# GOVERNMENT ARCHITECT NEW SOUTH WALES

Pitt Street South Over Station Development – Design Excellence

Sydney Metro Design  
Review Panel  
Letter of Design Excellence  
Pitt Street South Over  
Station Development

## REDUCTION IN FACADE DEPTH:

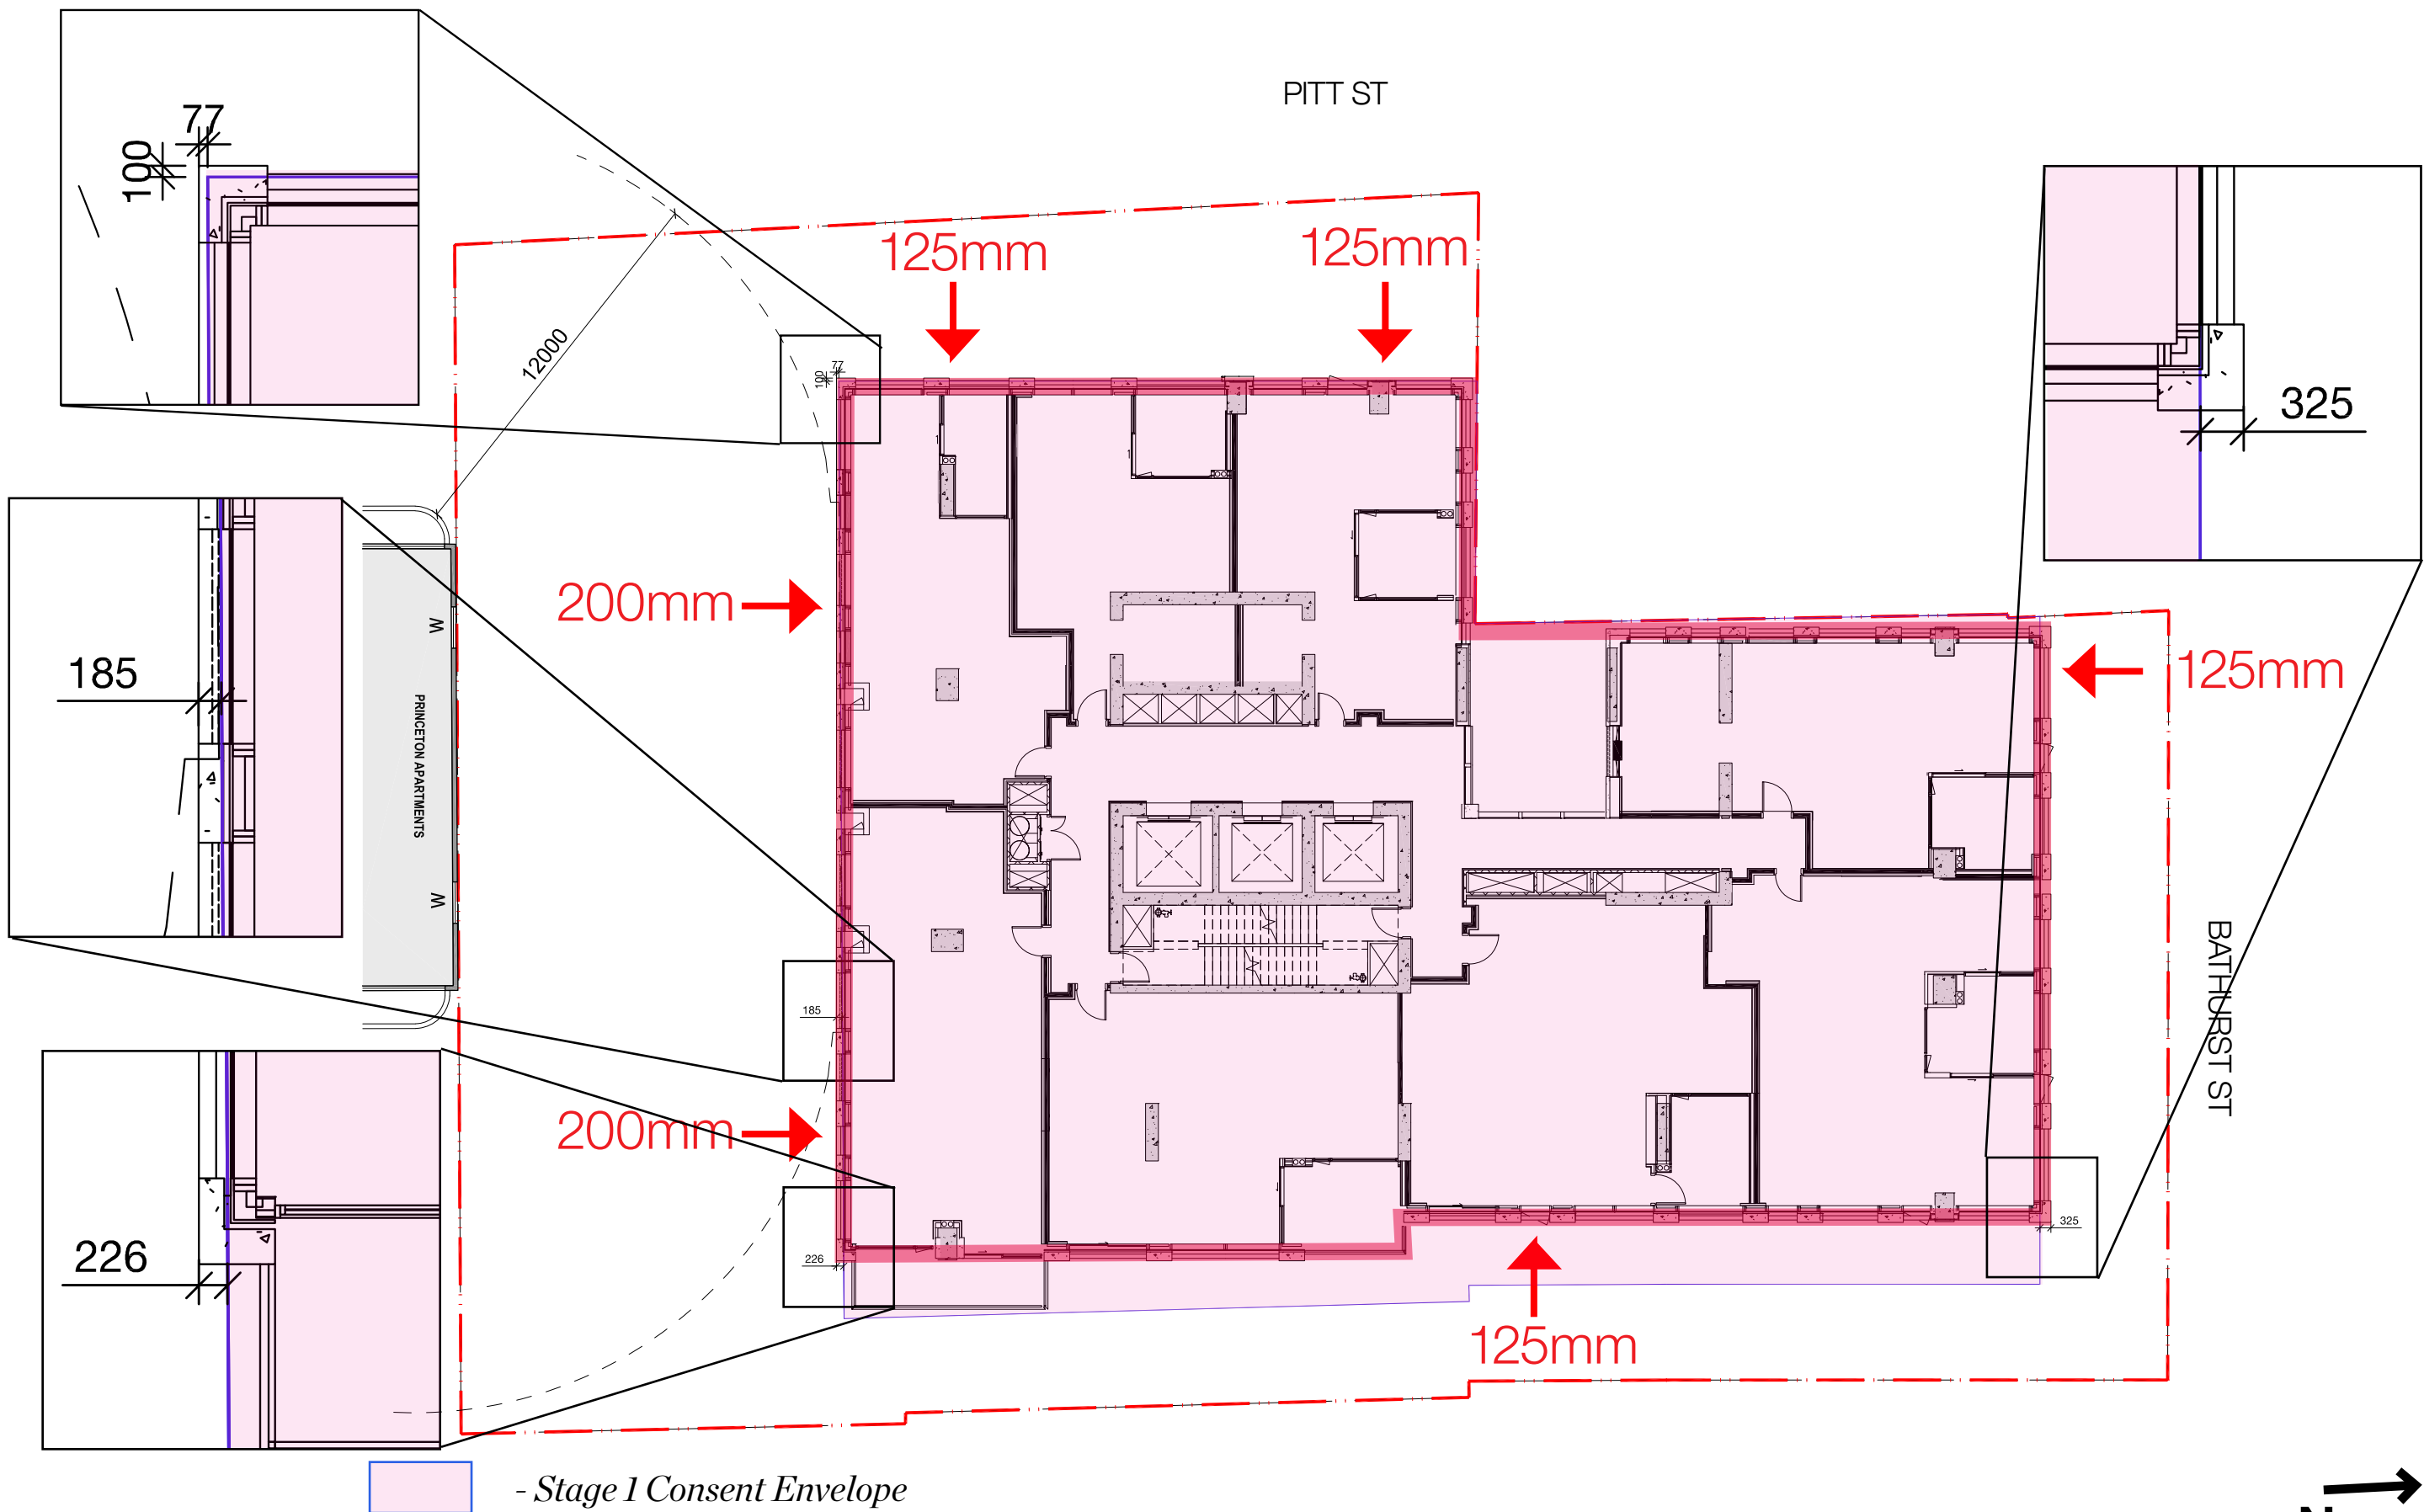
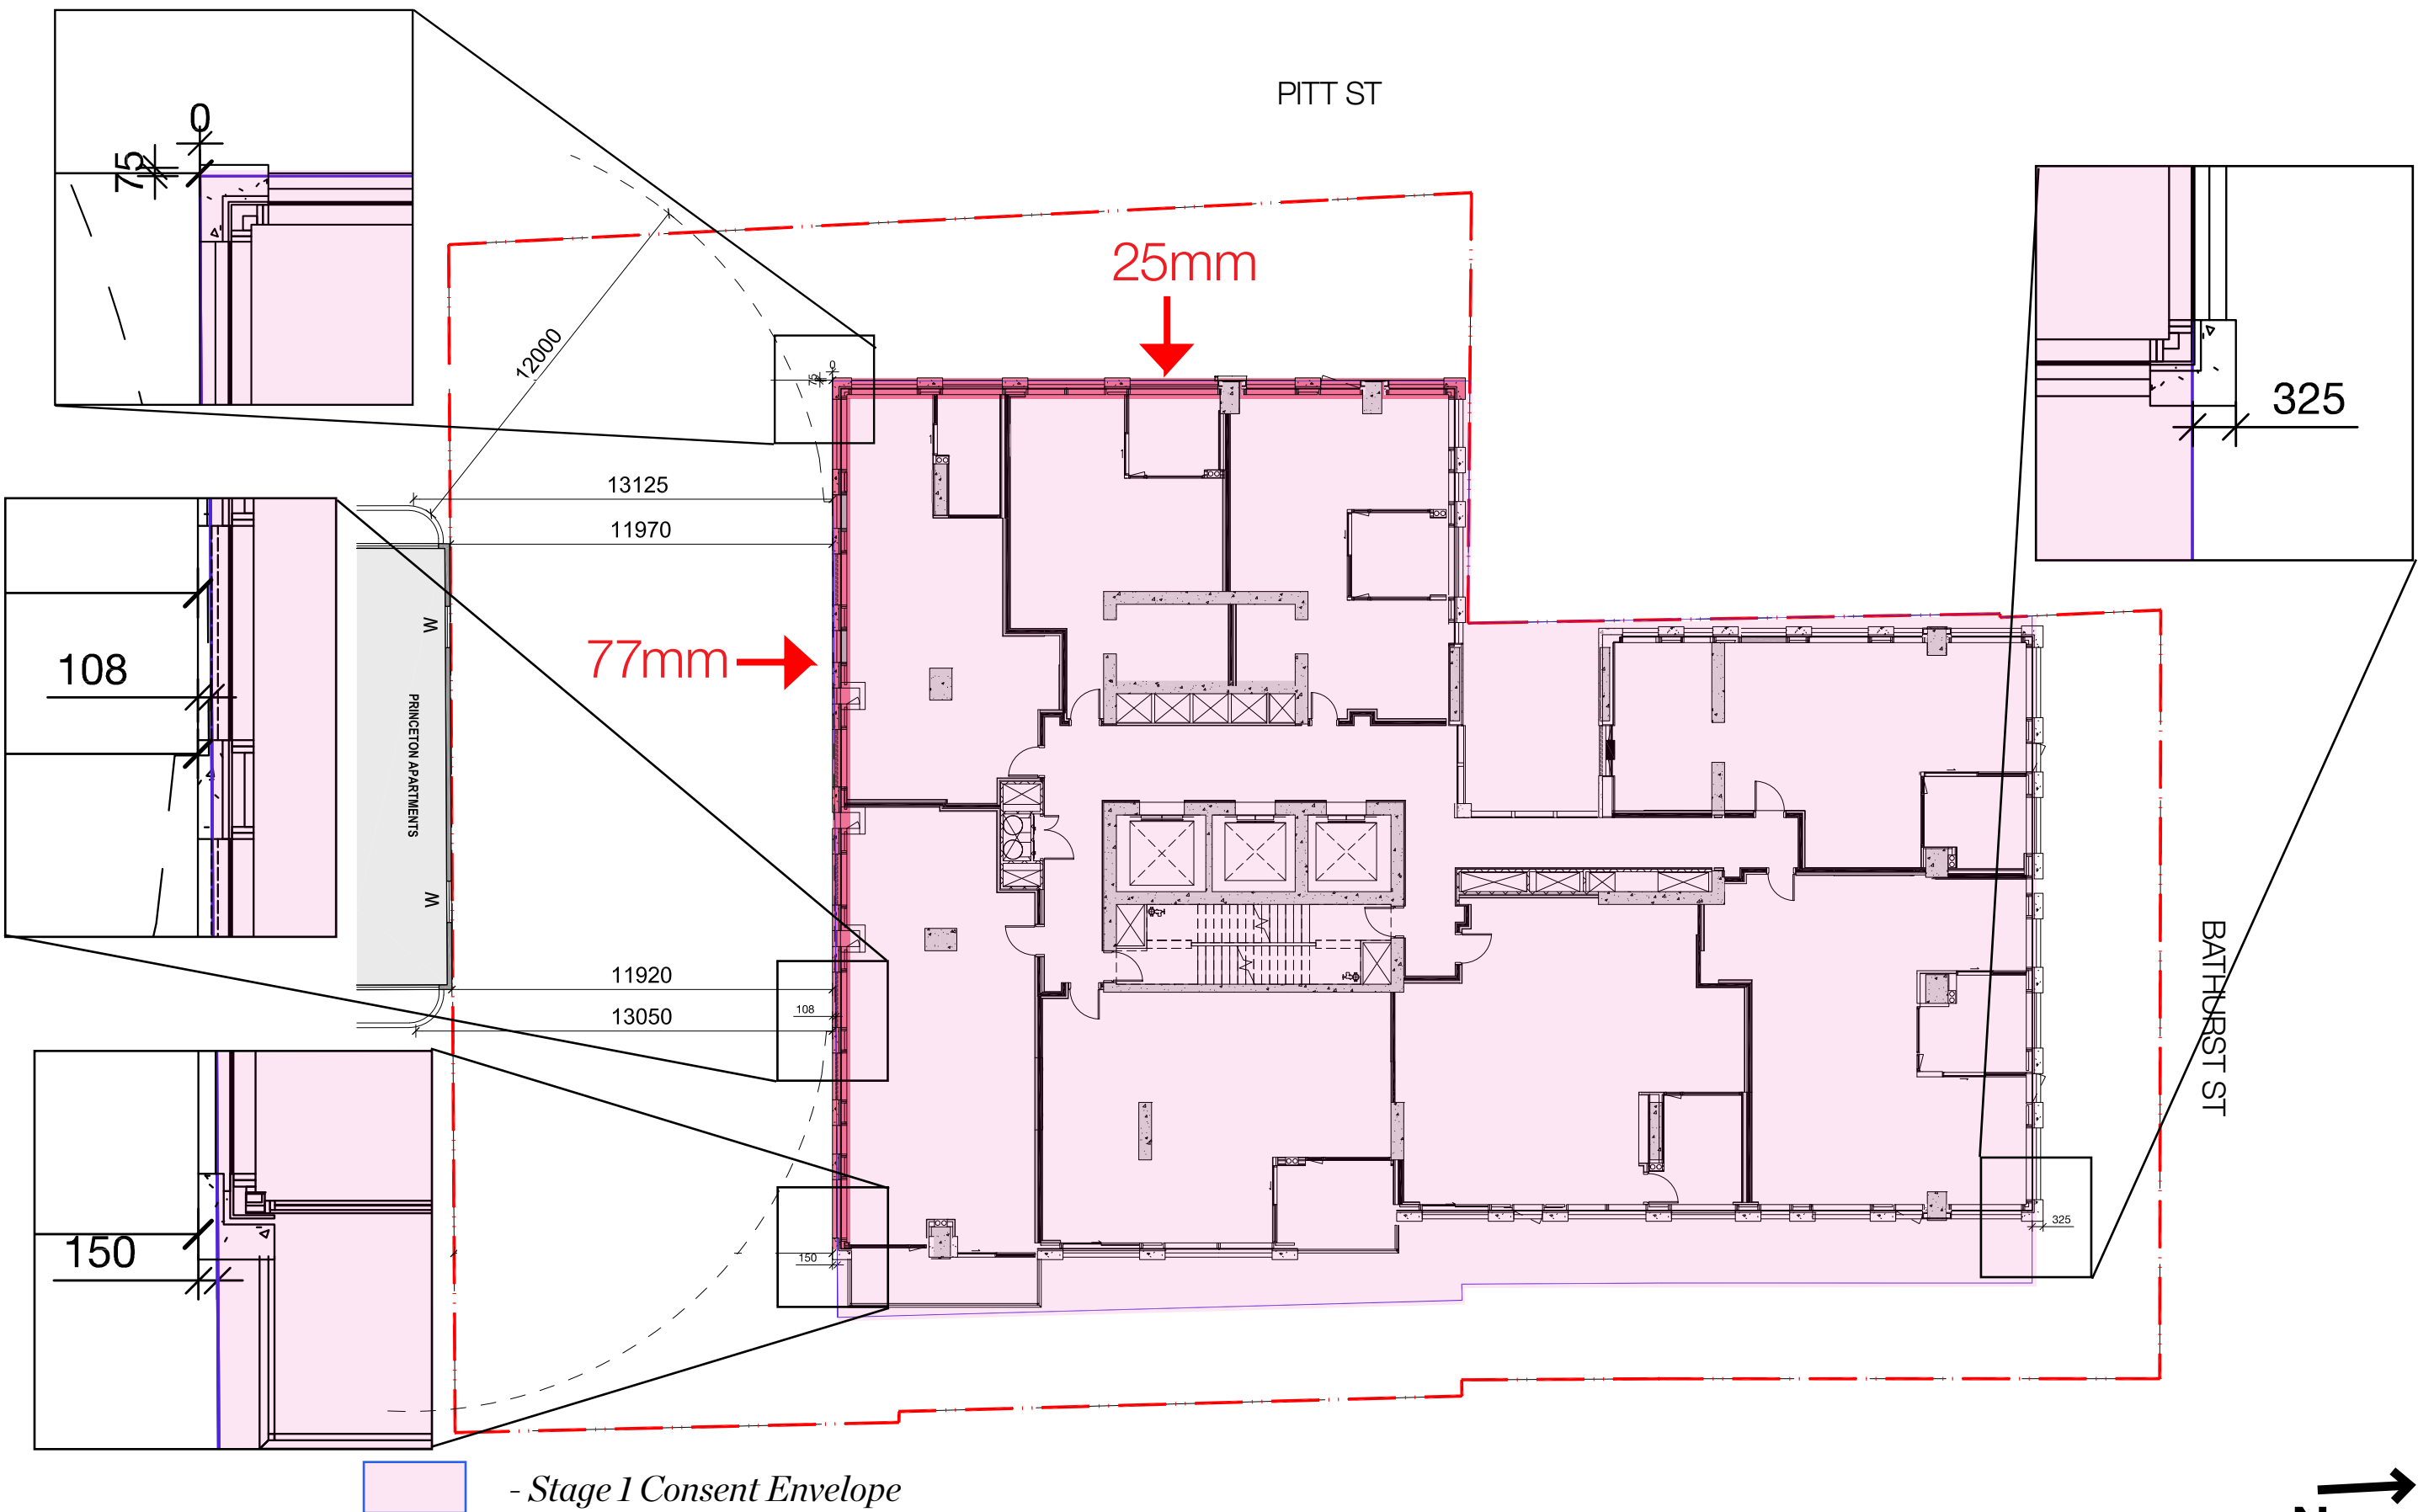
- **Façade depth**  
The Panel recommend that the expressed masonry depth of the façade (450mm from the glass line) be maintained on the north, east and west facades, note it was a key feature of the tendered design, provides the building with articulation and plays a role in the environmental performance of the façade.

- Tracker Item 11.03: The Panel does not currently support the reduction in façade depth to the west, east and northern façade panels however does support the updated consistency of width. The Panel acknowledges that the design team are confident of the decision to reduce the depth to 325mm from the original depth of 450mm and will review the full-scale details of the proposed façade depth to further their understanding of this decision.
